Please upload on Ocella for LU/121/17/RES confirming substitute brick type.

I hereby approve the proposed substitution of the Sutherland Blend brick, produced by Edenhall, with the Beaufort Blend brick, which is also manufactured by Edenhall, as shown on drawing 543-PL-SITE LAYOUT - 107 rev F.

The Beaufort Blend brick will be used in Phase 2 (LU/121/17/RES) at North Littlehampton Strategic Development Area .

Drawing Title:	
Site Layout - INFORMATION	
Drawing Status:	Drawn:
SUBMITTED	KJ
	Rev:
	-

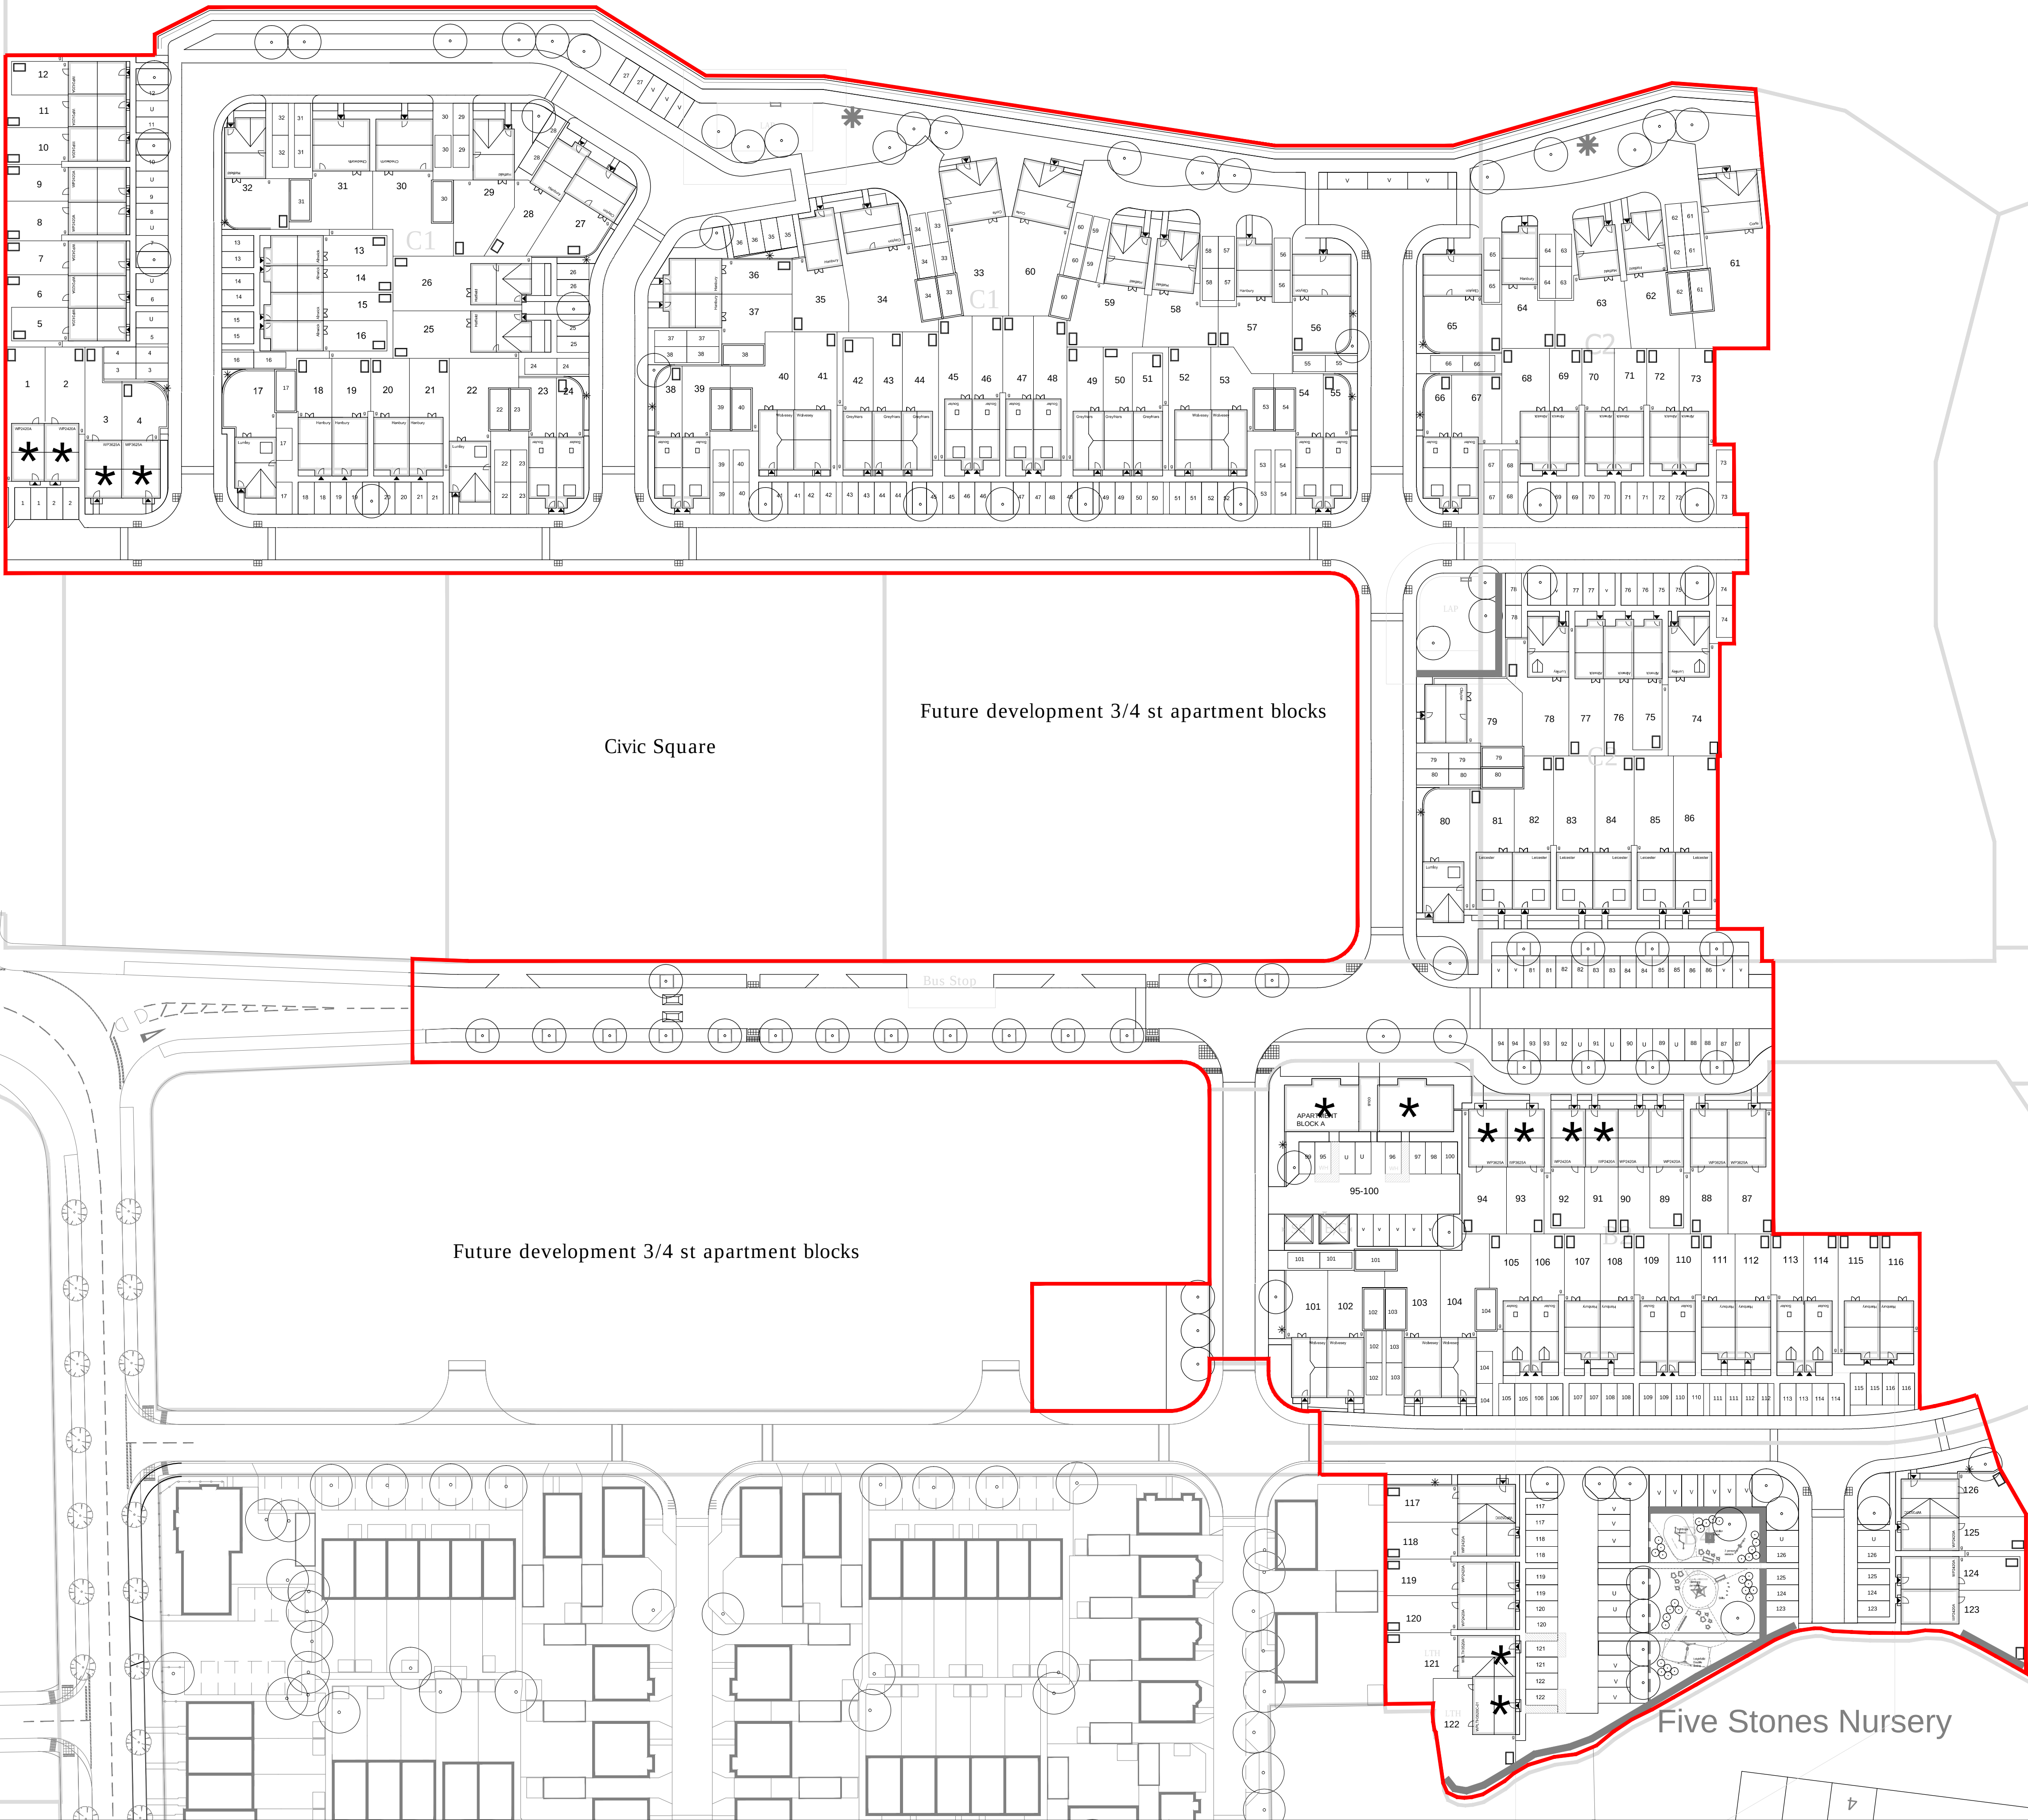
I have just been informed that one of the approved bricks for LU/121/17/RES is no longer available - namely the Sutherland Blend by Edenhall (its production has been discontinued - which is very annoying).

The proposed substitution is Beaufort Blend, also by Edenhall. It is extremely similar to the Sutherland Blend in that it is a pale brick with pink and grey hues, so I am hoping you can agree to the substitution.

Attached is drawing 543-PL-SITE LAYOUT - 107 rev F, which shows the Beaufort Blend.
